Lane Cove Council

26 October 2022

Redevelopment of Greenwich Hospital (Detailed Design)
at 97-115 River Road Greenwich (SSD-13619238)

REVISION: **P19**
DATE: 01/06/21
DRAWING TITLE:
PROPOSED SITE PLAN
DRAWN: NAH
CHECKED:
SCALE: 1 : 500 @A1

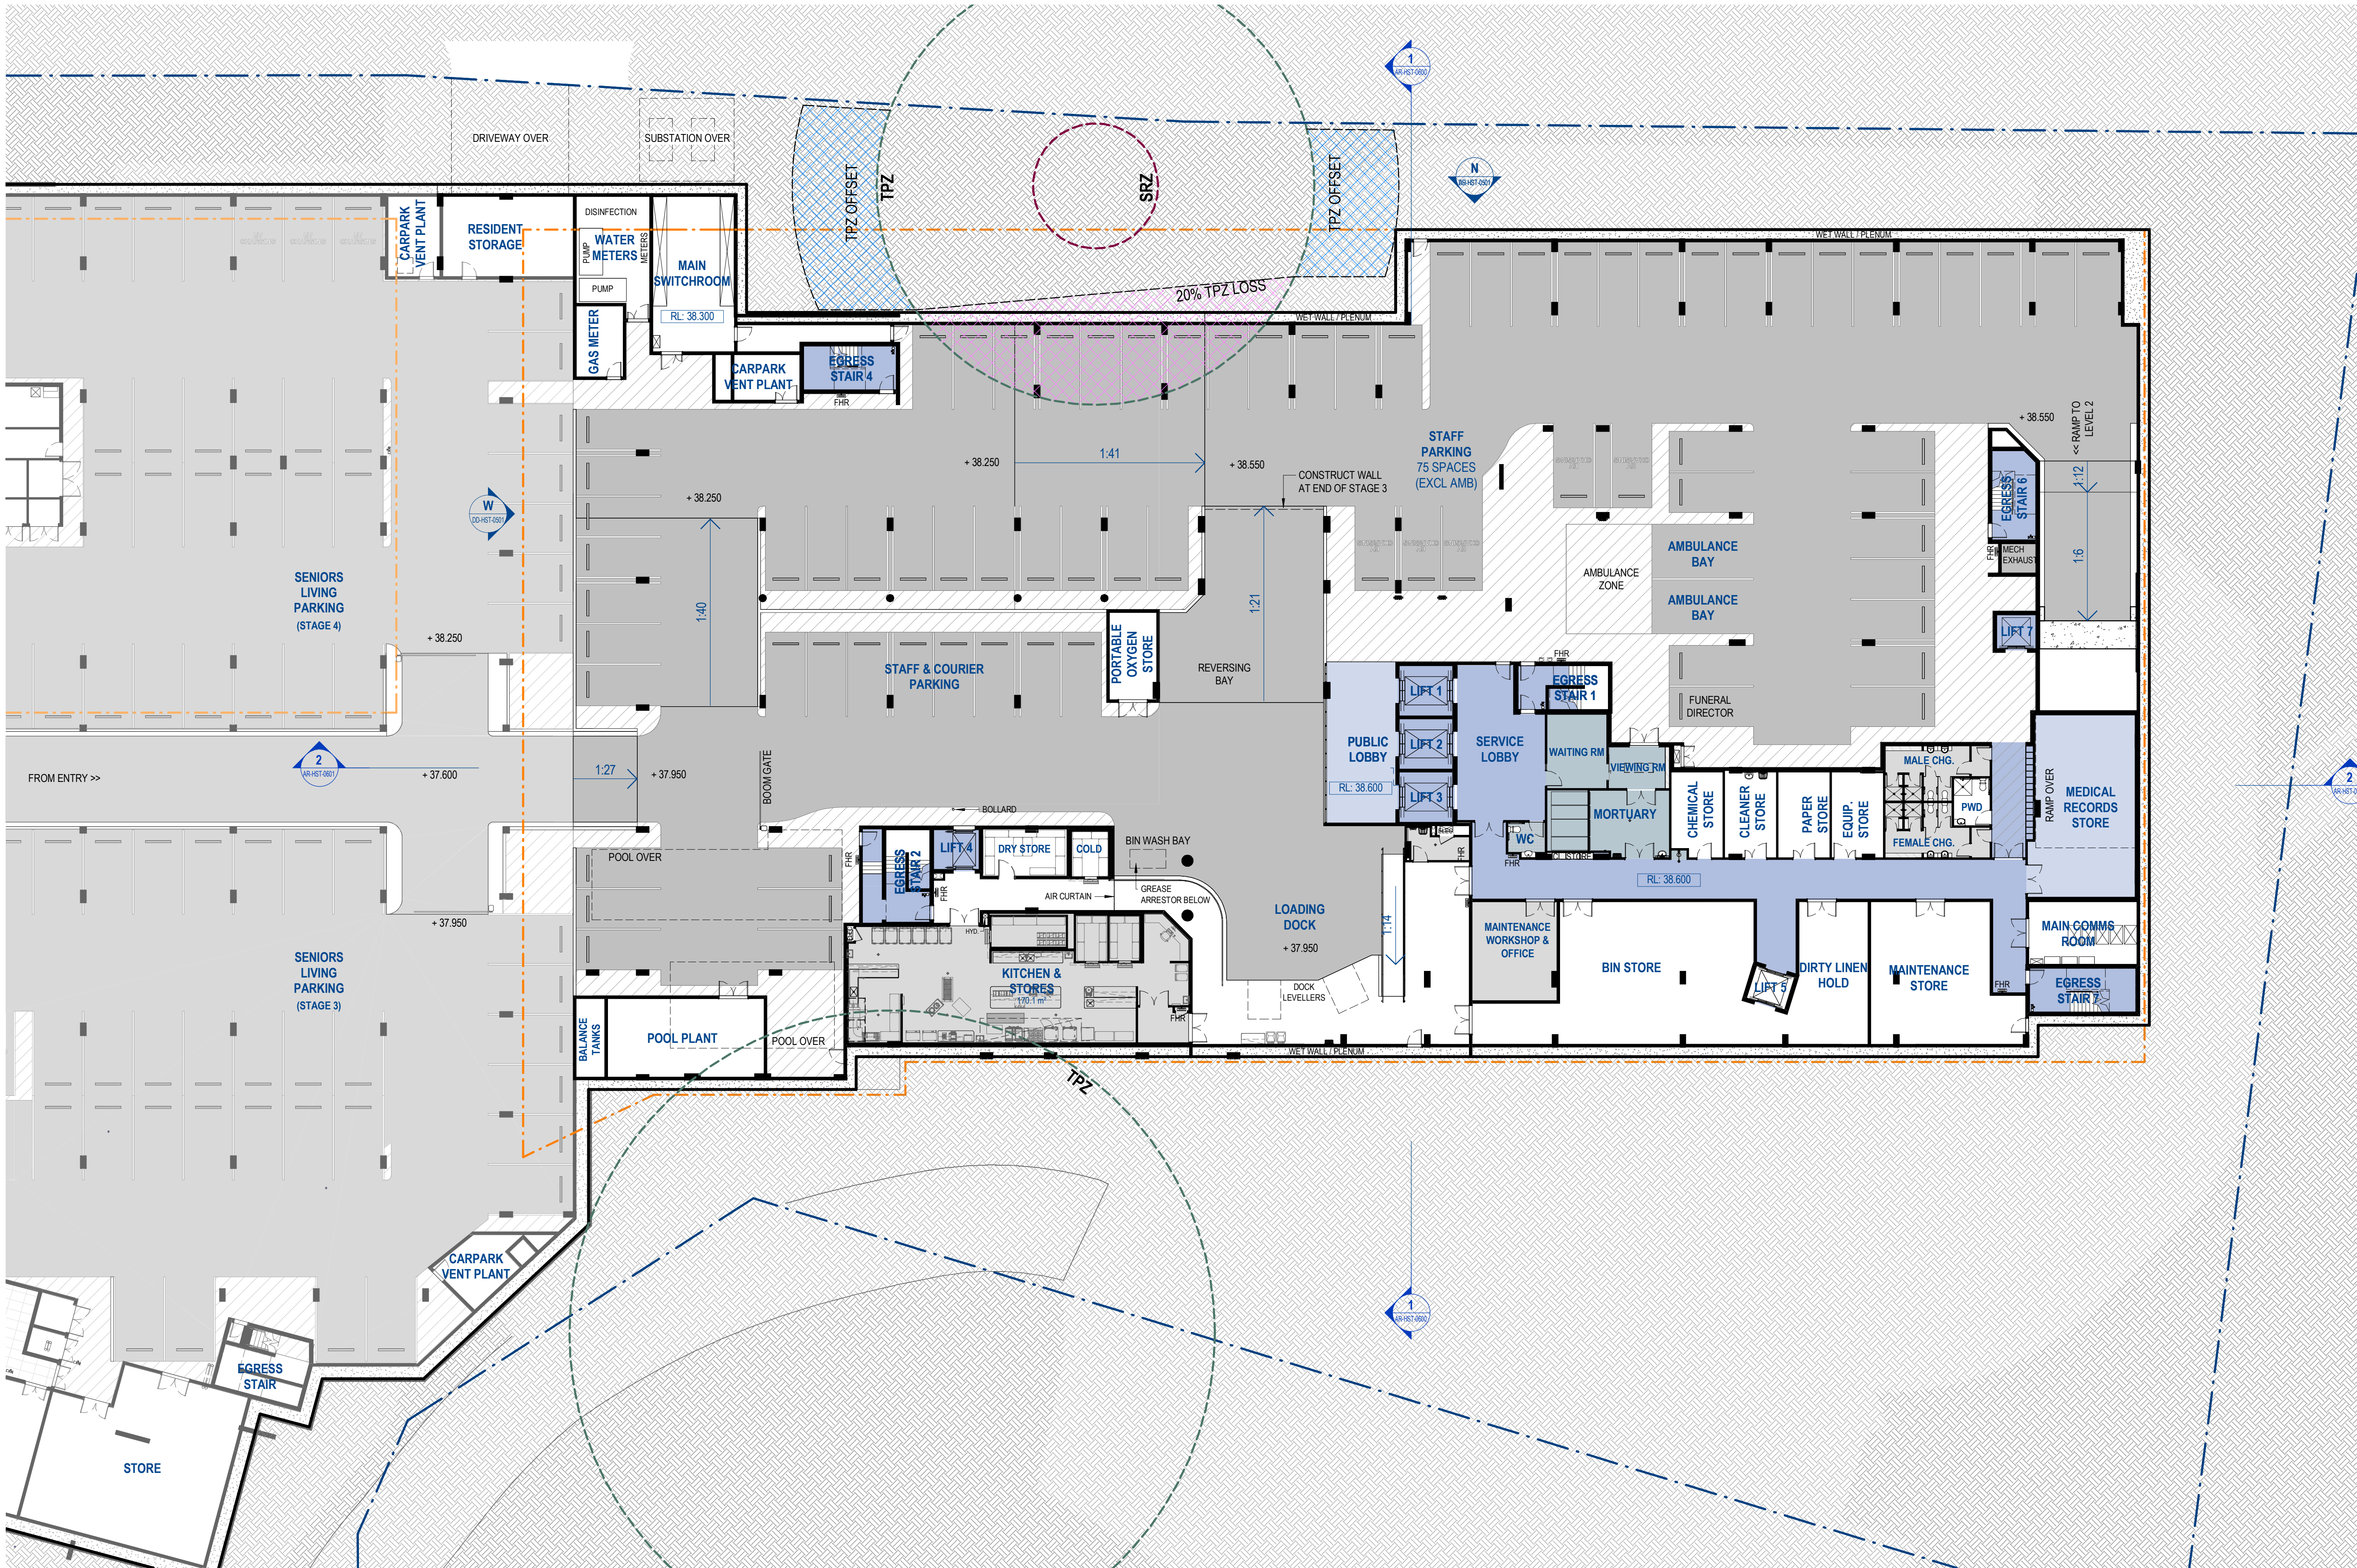
Council requests that HammondCare construct a pedestrian pathway within the site through the north/eastern corner to provide a Shared User Path (SUP) between St Vincent's Road to the traffic lights on River Road. The pathway should be constructed without the removal of any canopy trees. The path would help discourage children from crossing River Road at the intersection of St Vincents Road when travelling to/from Greenwich Public School.

Council requests that HammondCare construct a pedestrian pathway within the site through the north/eastern corner to provide a Shared User Path (SUP) between the St Vincent's Road to the traffic lights on River Road. The pathway should be constructed without the removal of any canopy trees.
